The submitted details are considered to be satisfactory and demonstrate reasonable provision.

Subject: Re The Martlets, East Preston.

Proposed Surface Water
Soakaway (To serve roof
slopes only)

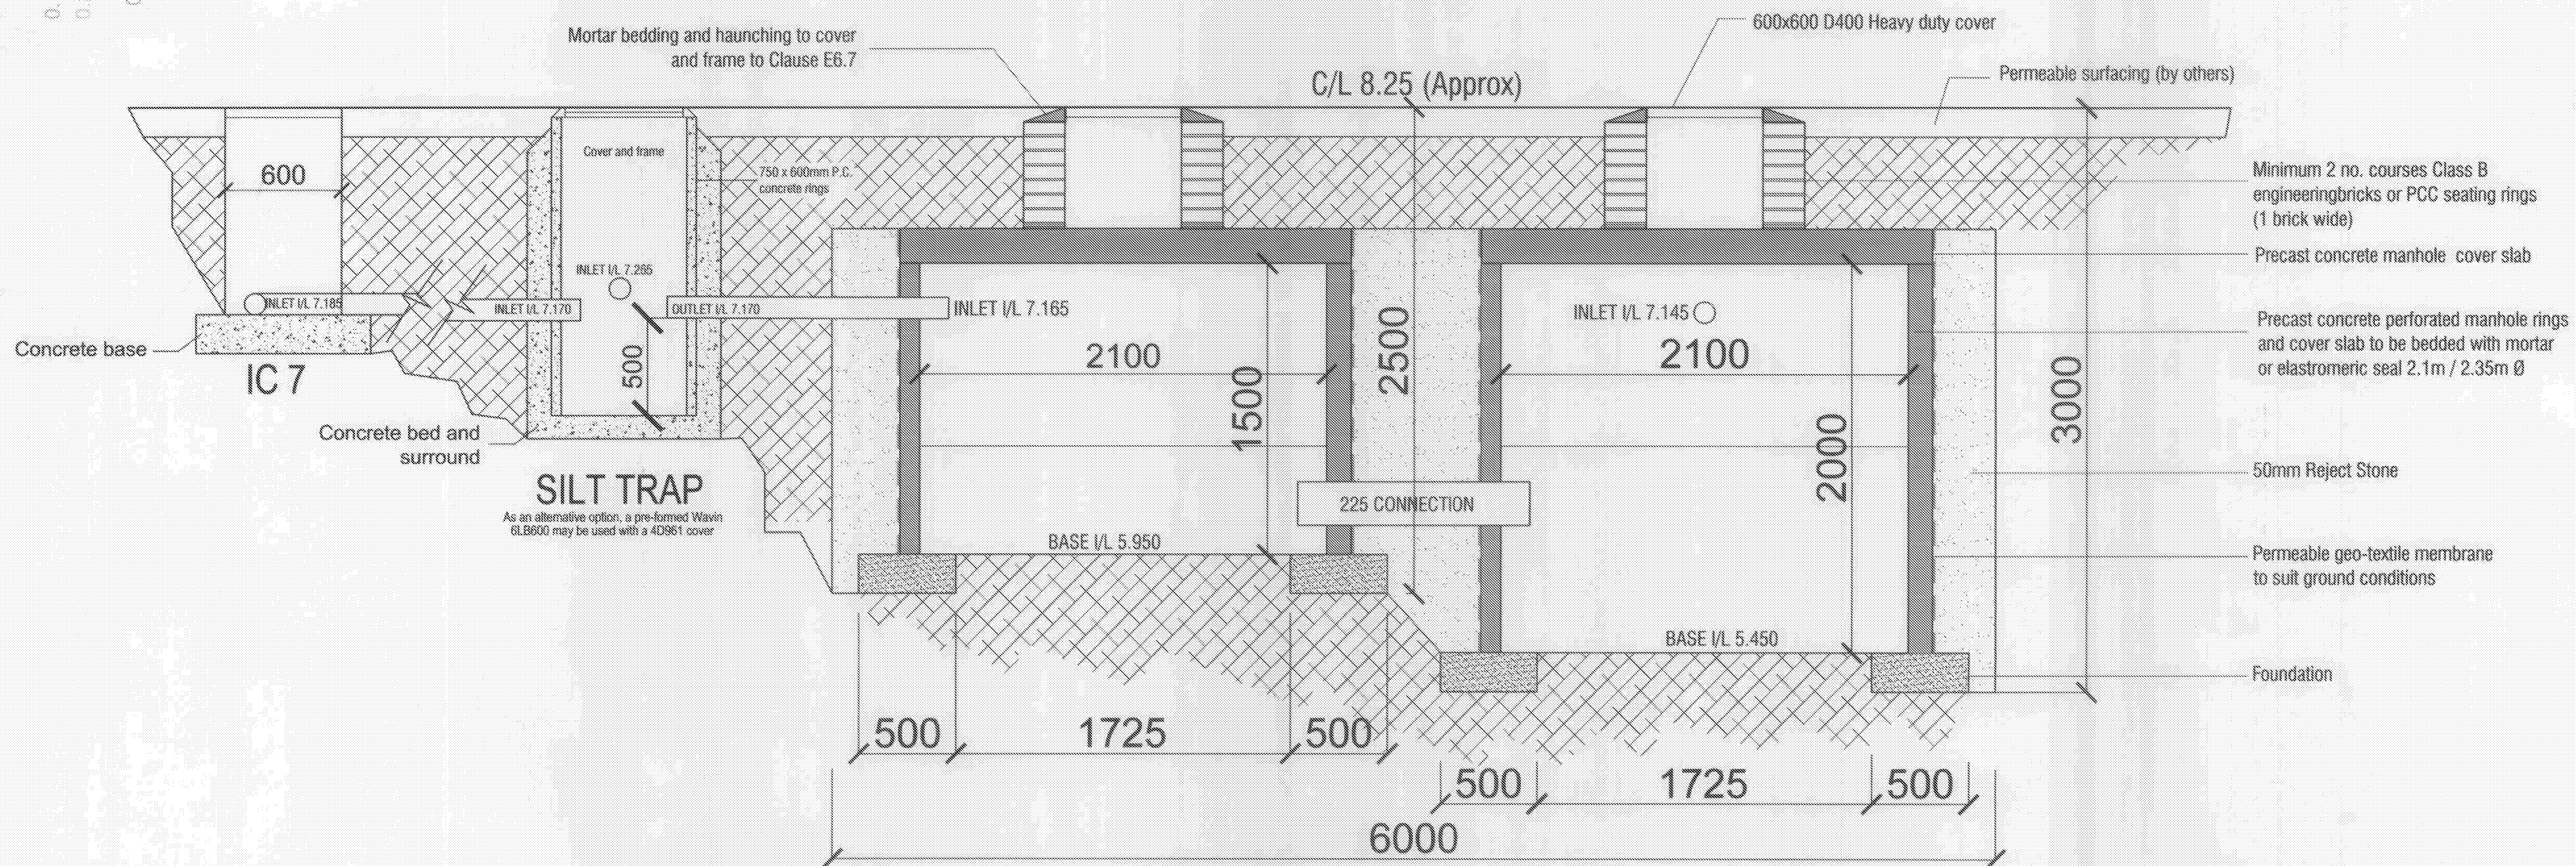
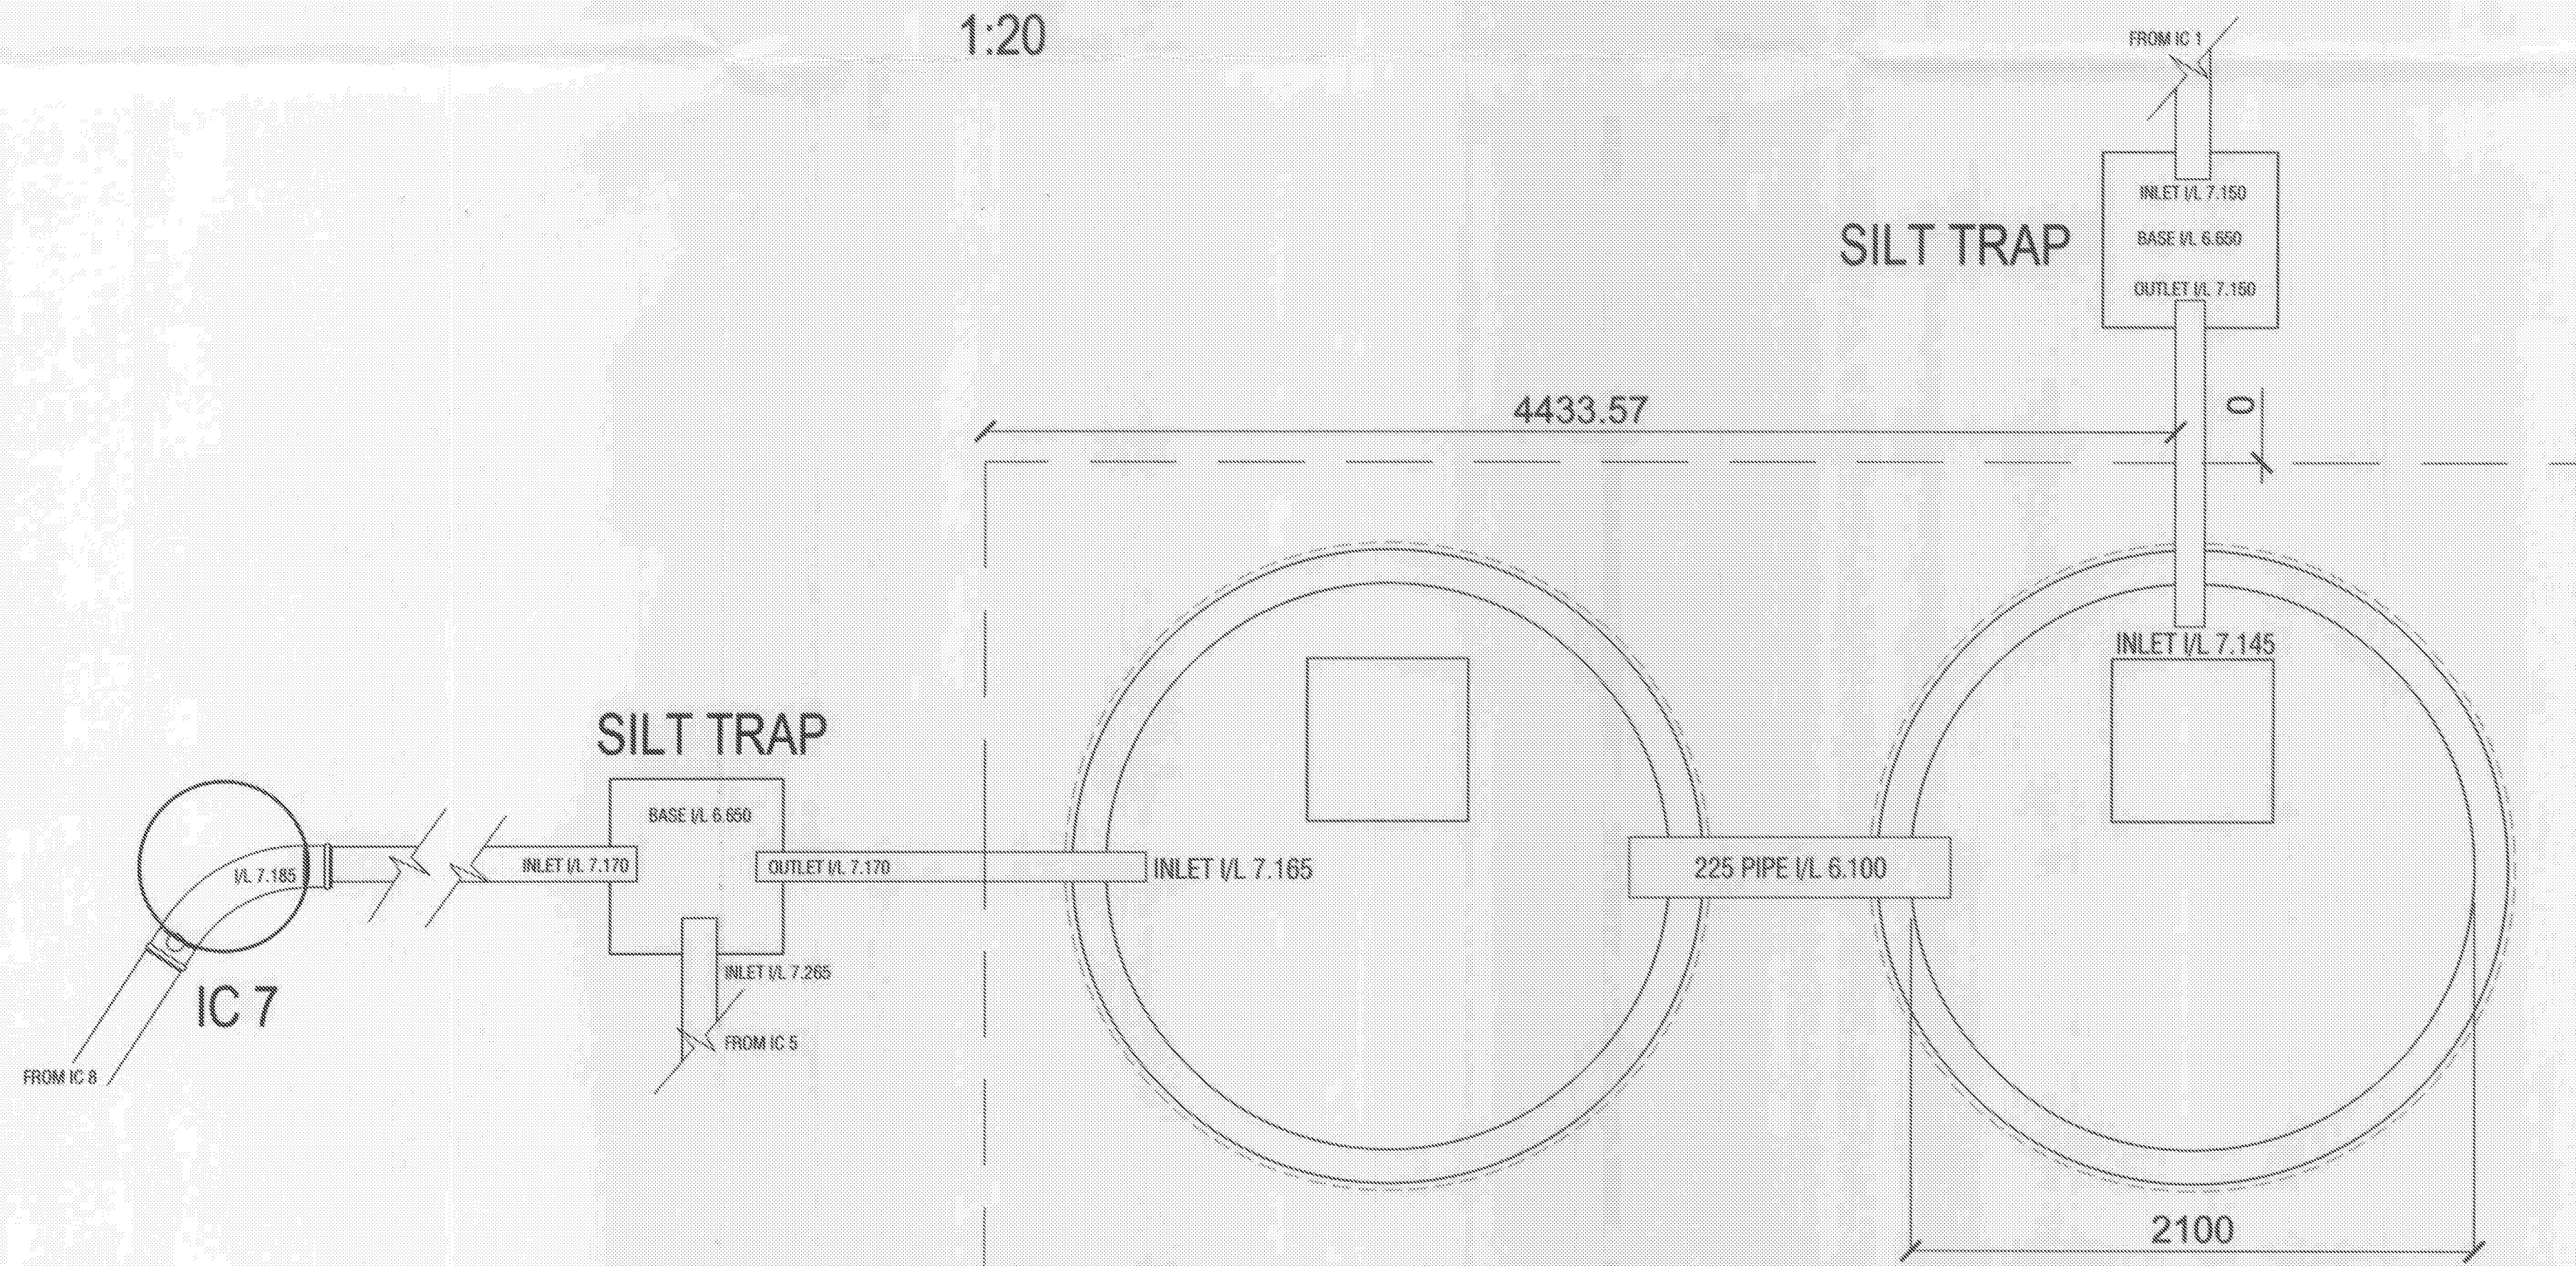
The following has been considered: a relationship between the head of water in the soakaway and the percolation rate has been demonstrated, and would likely increase as the head increases; the soakaway has been dug into a very sandy seam of ground; the roof area of the development appears to be less than twice the roof area of the original building, but the new soakaway probably has a capacity several thousand times greater than the soakaway serving the original building, and therefore represents a significant improvement which should result in a reduced risk of failure.
